Sydney Zoo – Notice of Exhibition

Annexure A to Sydney Zoo Notice of Exhibition SSD7228

SYDNEY ZOO TRAFFIC ASSESSMENT
14.5m LONG RIGID BUS
SWEPT PATH ASSESSMENT

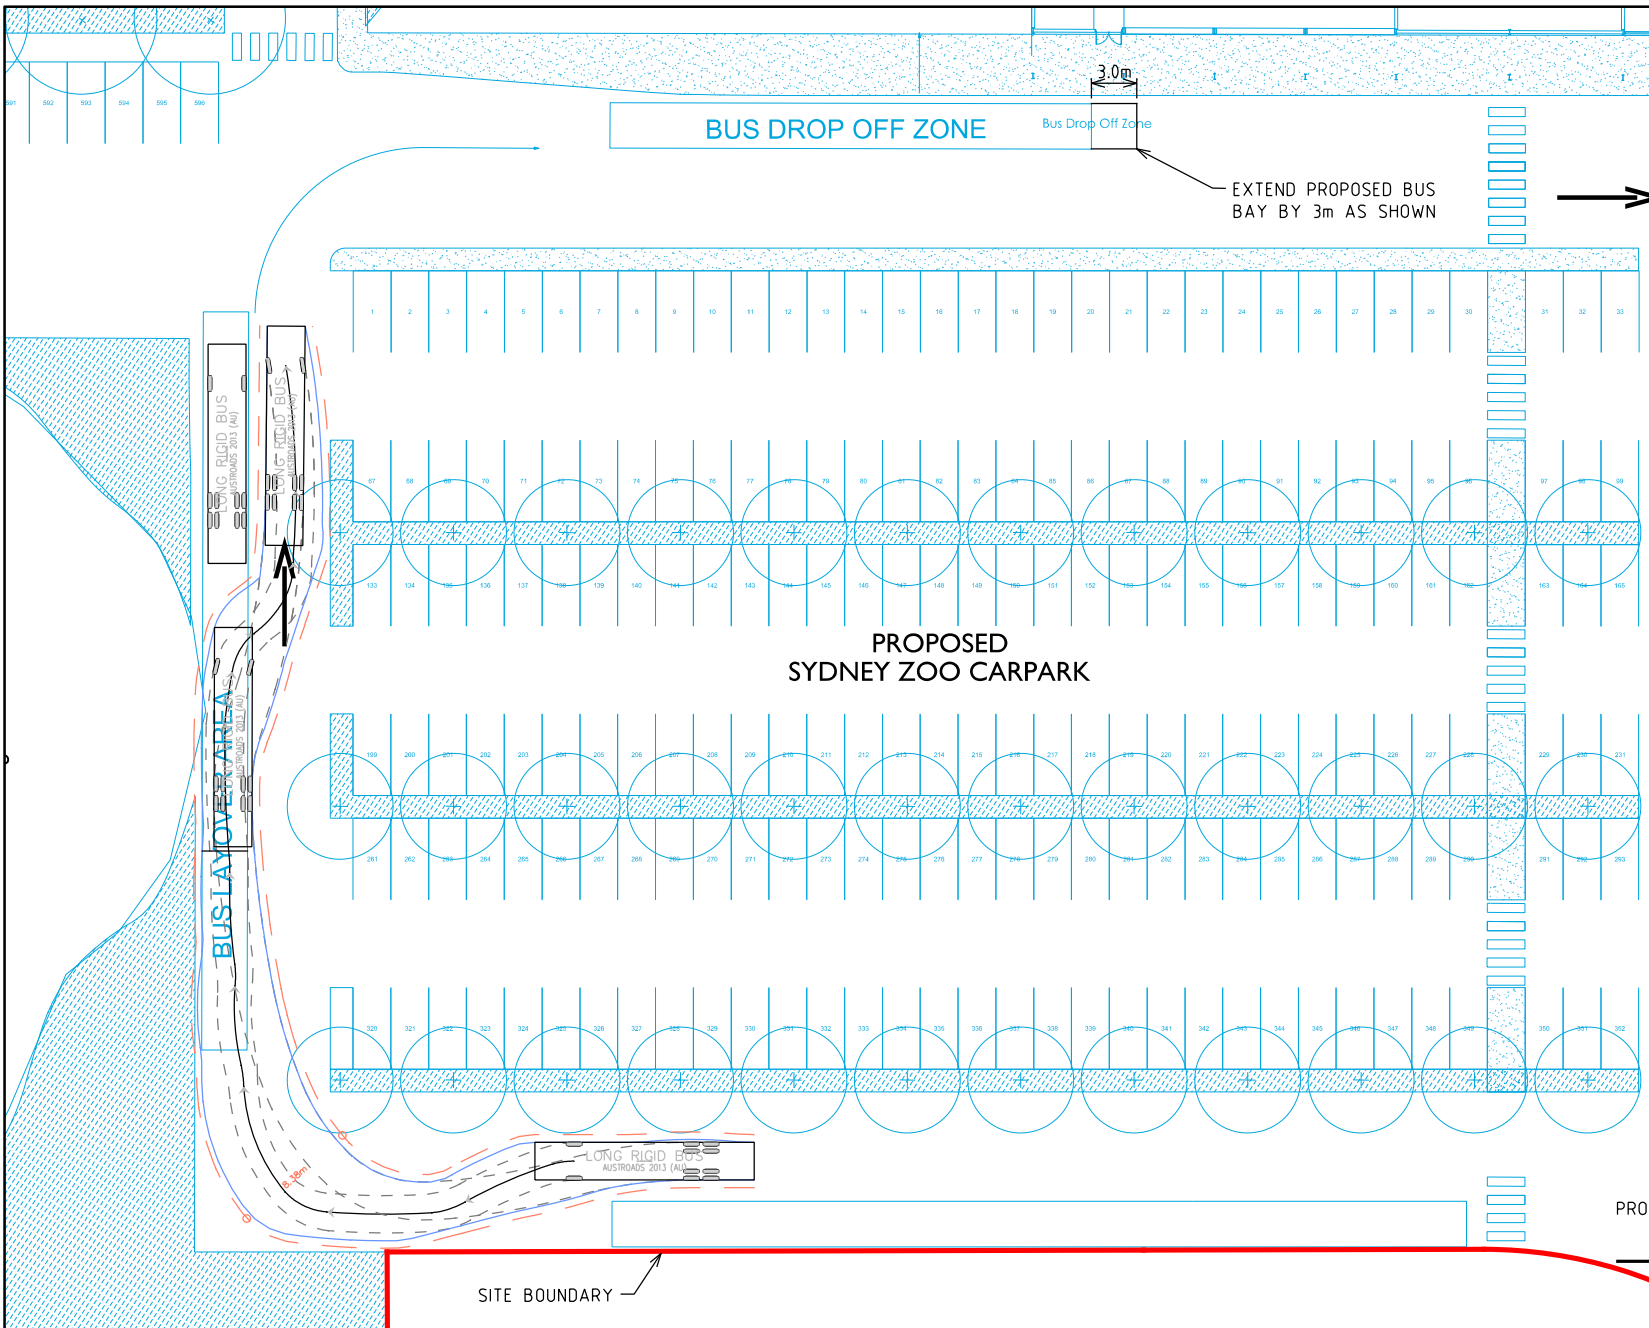
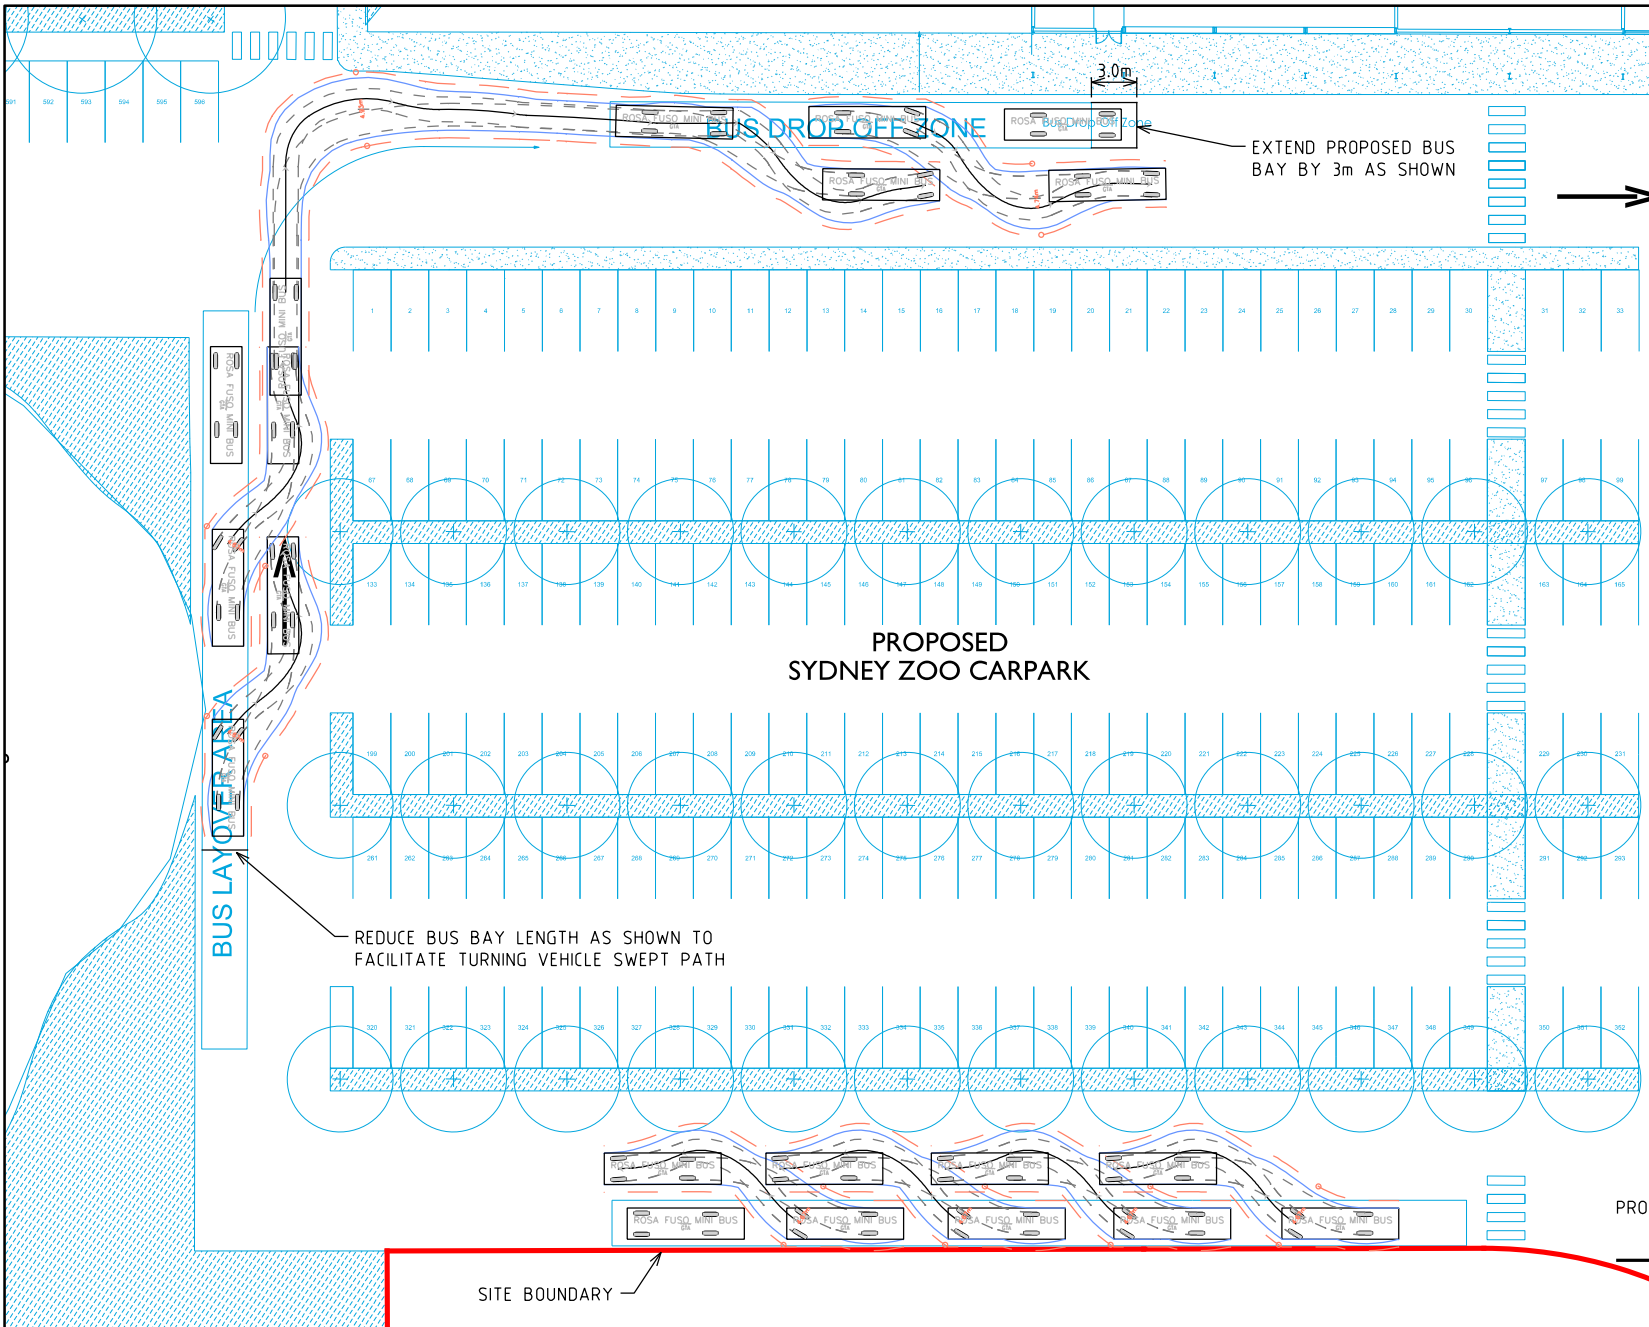
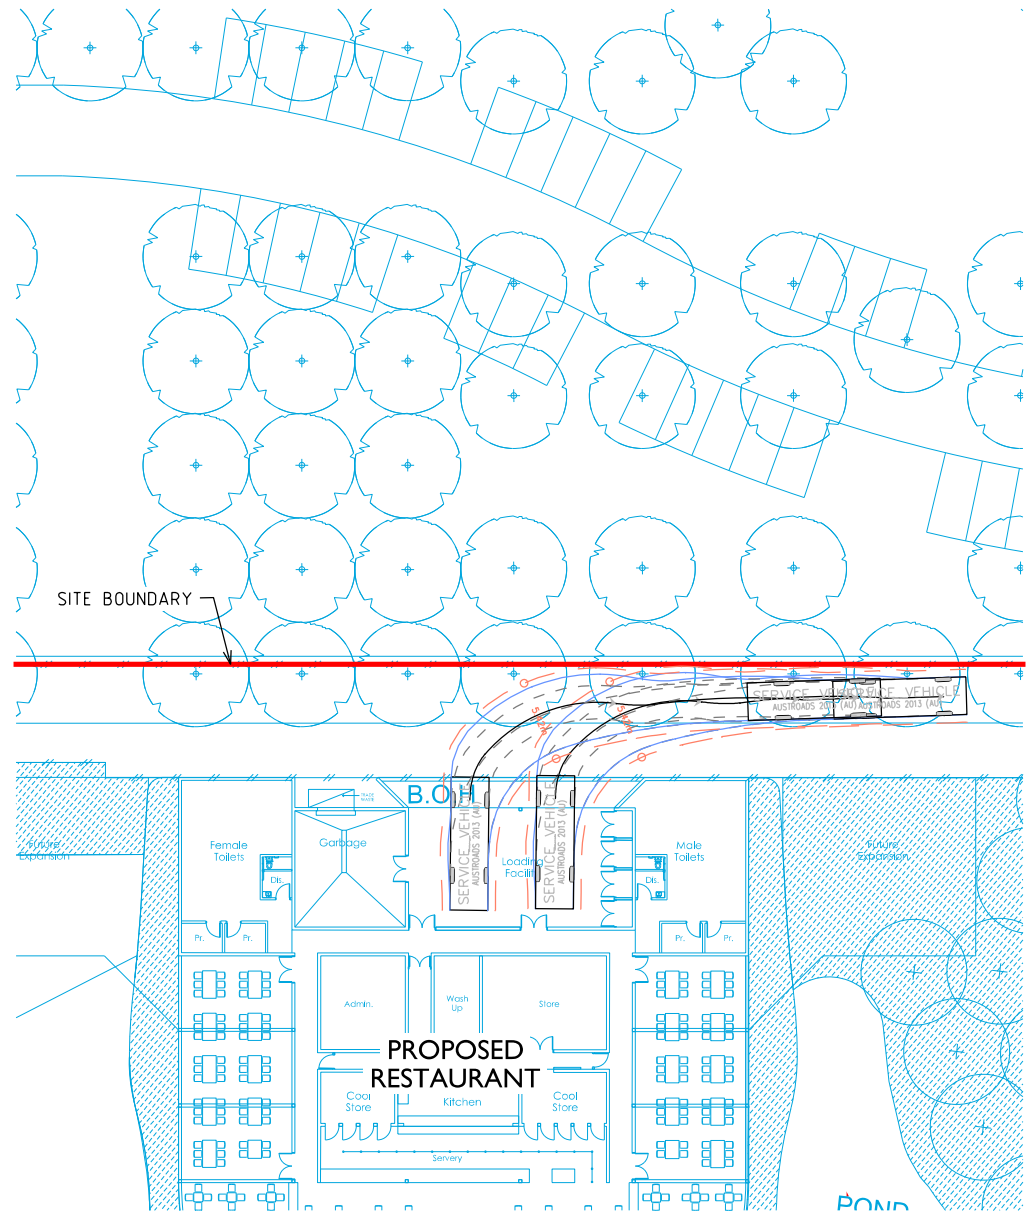
- Swept path analysis has not been provided for heavy vehicles and buses from Great Western Highway into the site.

- The proponent should be conditioned to provide swept path analysis demonstrating heavy vehicles and buses enter the site from Great Western Highway.
